**SSI-22338205, KURRI KURRI LATERAL PIPELINE PROJECT, RESPONSE TO SUBMISSIONS REPORT; LOT: 51 DP: 1158920 AND OTHERS, M1 PACIFIC MOTORWAY, JOHN RENSHAW DRIVE AND CESSNOCK MAIN ROAD**

### TfNSW advice and conditions – Kurri Kurri Lateral Pipeline SSI-22338205

**FIGURE 2.1A**  
**Project Alignment and Construction Footprint**

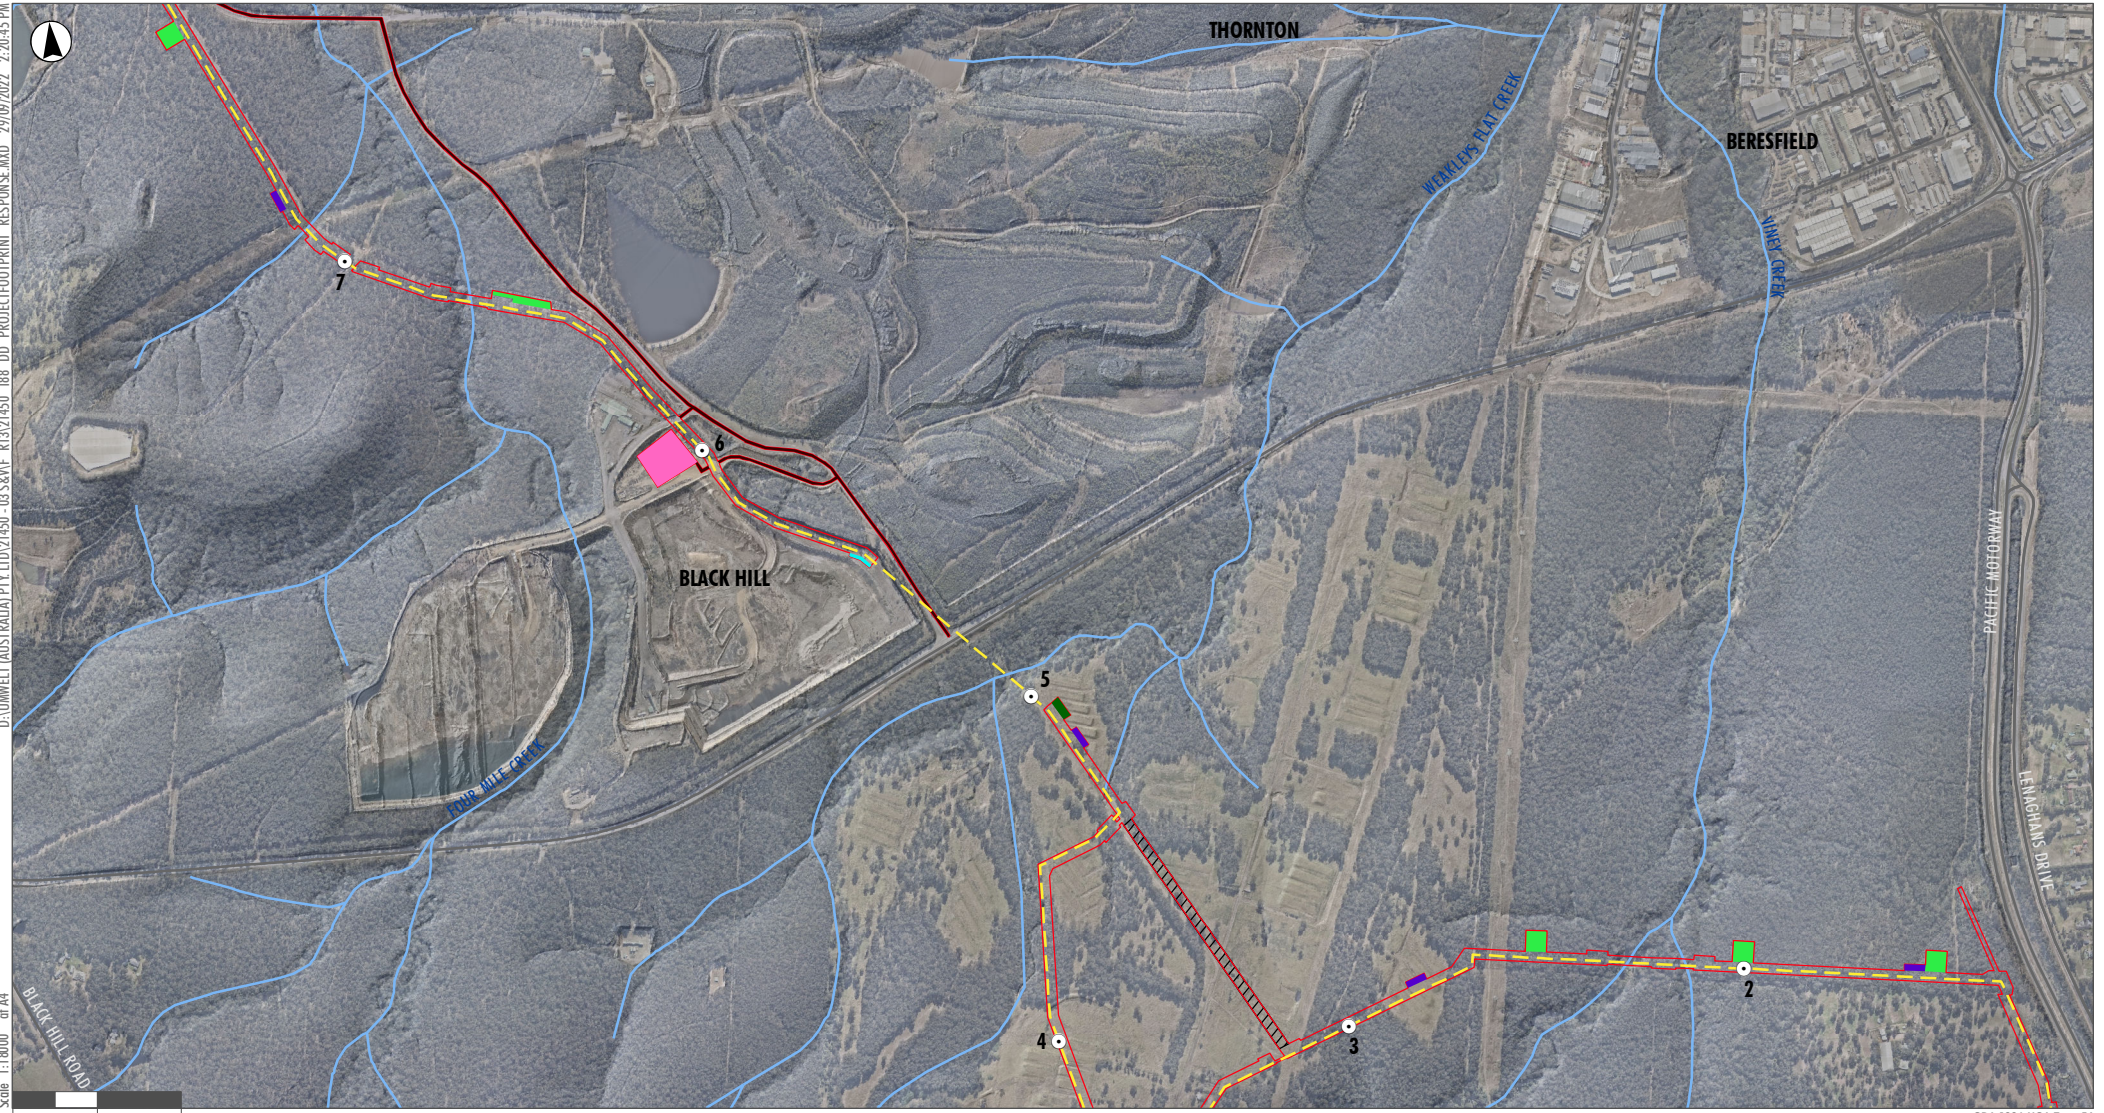
- Unless otherwise agreed in writing from TfNSW, the crossing locations and depths are to be generally to be in accordance with (but without limiting requirements):

- SSI Amendment Report (Umwelt, September 2022) Appendix A Figure 2.1A (M1 Motorway and Lower Hunter Freight Corridor), Figure 2.1B (John Renshaw Drive), and Figure 2.1E (Main Road); and

- In regard to the four (4) crossings of State Roads / Lower Hunter Freight Corridor:
  - The crossings are to be by Horizontal Directional Drilling or Thrust Boring (trenchless) methodology unless otherwise agreed in writing from TfNSW.

FIGURE 2.1E  
Project Alignment and  
Construction Footprint

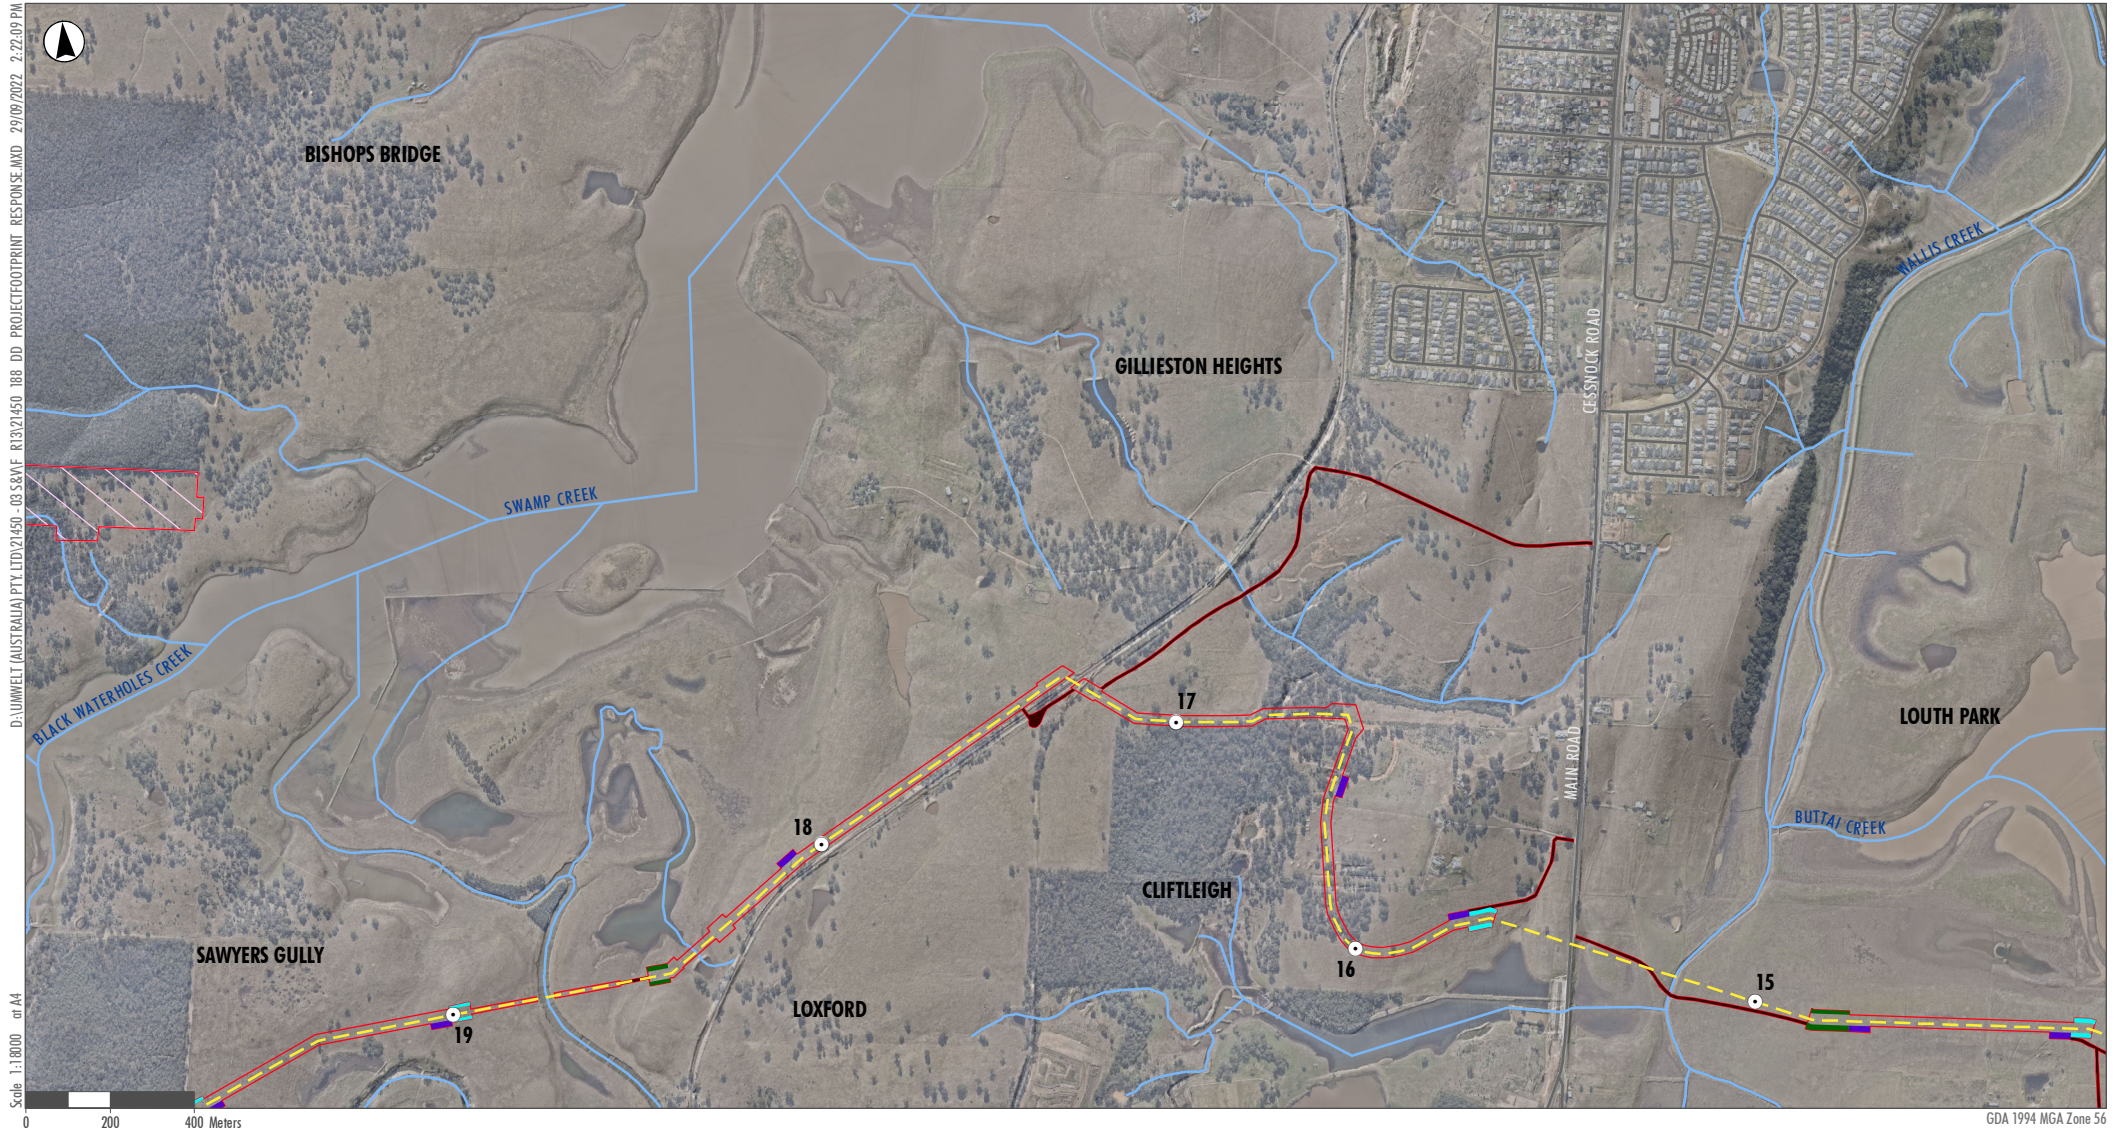
(Note: at the time of this letter final detailed designs for John Renshaw Drive and Main Road crossings had not been received by TfNSW).
  - Prior to commencing construction, suitable evidence in the form of geotechnical observations, advice and modelling must be prepared to demonstrate the pipeline is capable of sustaining soil consolidation, vibration and surcharge loads caused by the passage of trains associated with the Lower Hunter Freight Corridor without compromising pipeline and railway operational and safety requirement to the satisfaction of TfNSW.
  - Prior to commencing construction, suitable evidence in the form of geotechnical observations, advice and modelling must be prepared to demonstrate pipeline installation under the Black Hill interchange road overpass will not be affected by, and will not affect, the structural loading,
